Comments on the Responses by Tritax Symmetry (Hinckley) Ltd to my Written Representation to the Examining Authority (ExA) regarding the Environmental Statement submitted by Tritax Symmetry (Hinckley) Ltd in respect of their proposed Hinckley National Rail Freight Interchange and with particular reference to Chapter 10: Noise and vibration

Deadline for receipt of Comments to Responses: Tuesday 14th November 2023

Unique Reference Number: 20040614

Figure 1 – Identified Existing Sensitive Receptors

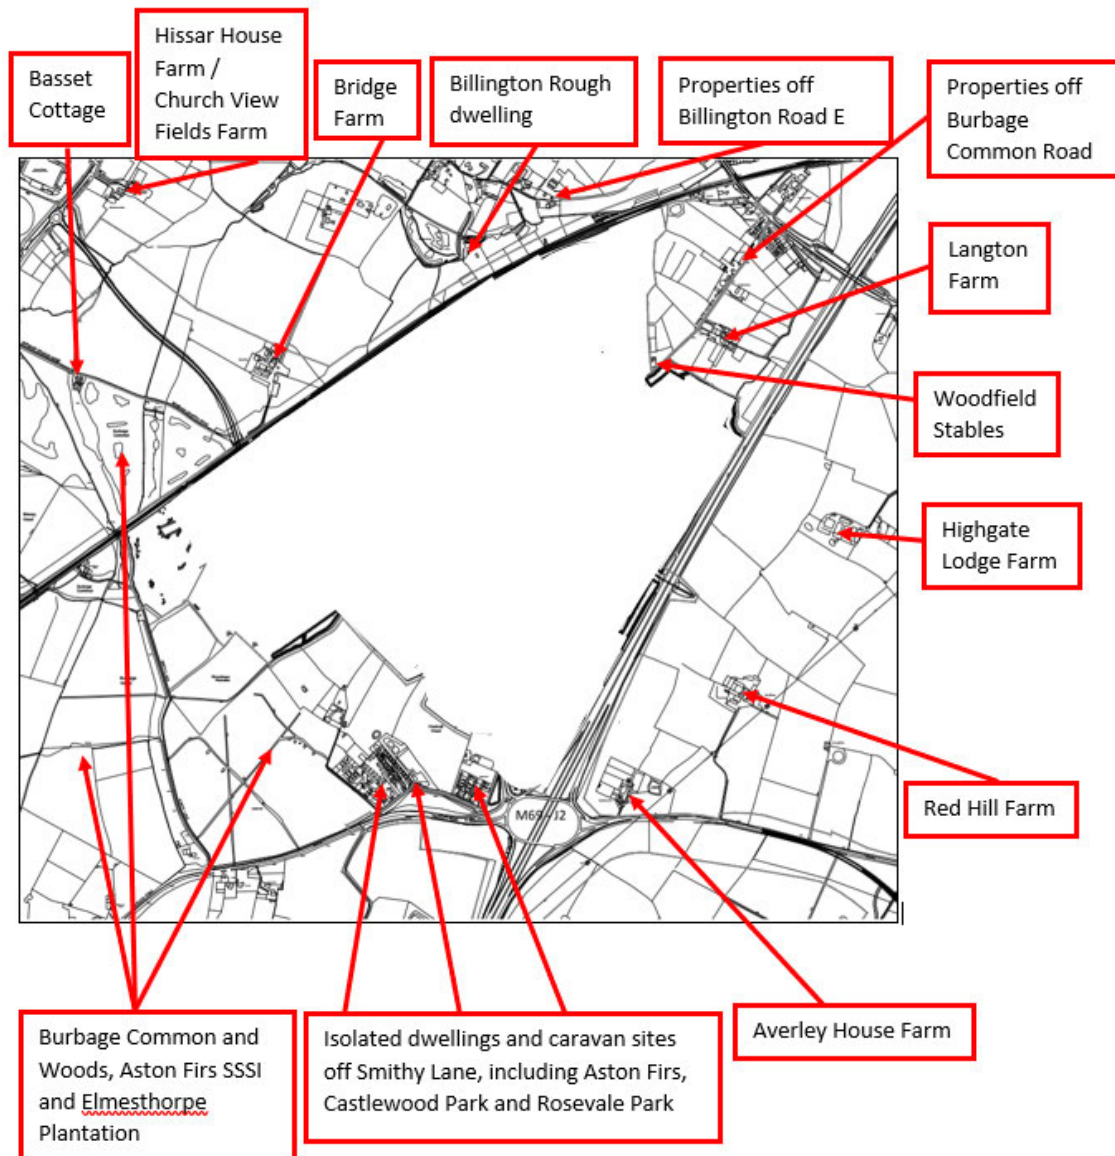
In Section 1 of my Written Representation, which ran to 5½ pages, I described in detail how Tritax had taken the ambient (L_{Aeq}) noise levels they recorded at the Noise Monitoring Positions (NMPs) adjacent to the trackside (or roadside), and simply imposed them upon the Noise Sensitive Receptors (NSRs) without applying any attenuation to the ambient noise levels for the train pass bys, even though some of those NSRs are hundreds of metres away from the track (or road).

In the latter part of Section 1, I also described in detail how Tritax had failed to indicate the distance at which the Noise Monitoring Positions (NMPs) had been placed away from the trackside (or roadside) and that the ambient (L_{Aeq}) and maximum ($L_{Amax,f}$) noise levels they recorded were dependent upon that distance, and so had no real meaning unless those distances were known. I explained that my observation of the site indicated that NMP4 was placed at no more than 12 metres from the nearside rail of the closest trainline.

Finally, I outlined that once those distances were confirmed, it would be possible to calculate the **actual** ambient (L_{Aeq}) and maximum ($L_{Amax,f}$) noise levels at the NSRs from the NMP data already available from the Noise and vibration report.

"As set out in Table 10.1 of the ES Noise and vibration chapter, the noise monitoring methodology has been detailed within the technical note NTT2814 –Hinckley Survey Method Statement_Issue_PO2 (document reference: 6.2.10.5, APP-184), which has been submitted to and agreed with Blaby District Council and Hinckley and Bosworth Borough Council – in both cases it was agreed by suitably qualified technical officers."

As you will see, Tritax did not engage with any of the points I raised. The Method Statement to which they refer (of which of course I was already aware) is purely a procedural document, that can have no sway upon the ambient (L_{Aeq}) and maximum ($L_{Amax,f}$) noise levels that NSRs actually experience. Also, Tritax do not indicate that they support the Method Statement, rather, their aim seems to be to pass a measure of responsibility for their Noise and vibration report to Blaby District Council and Hinckley and Bosworth Borough Council.
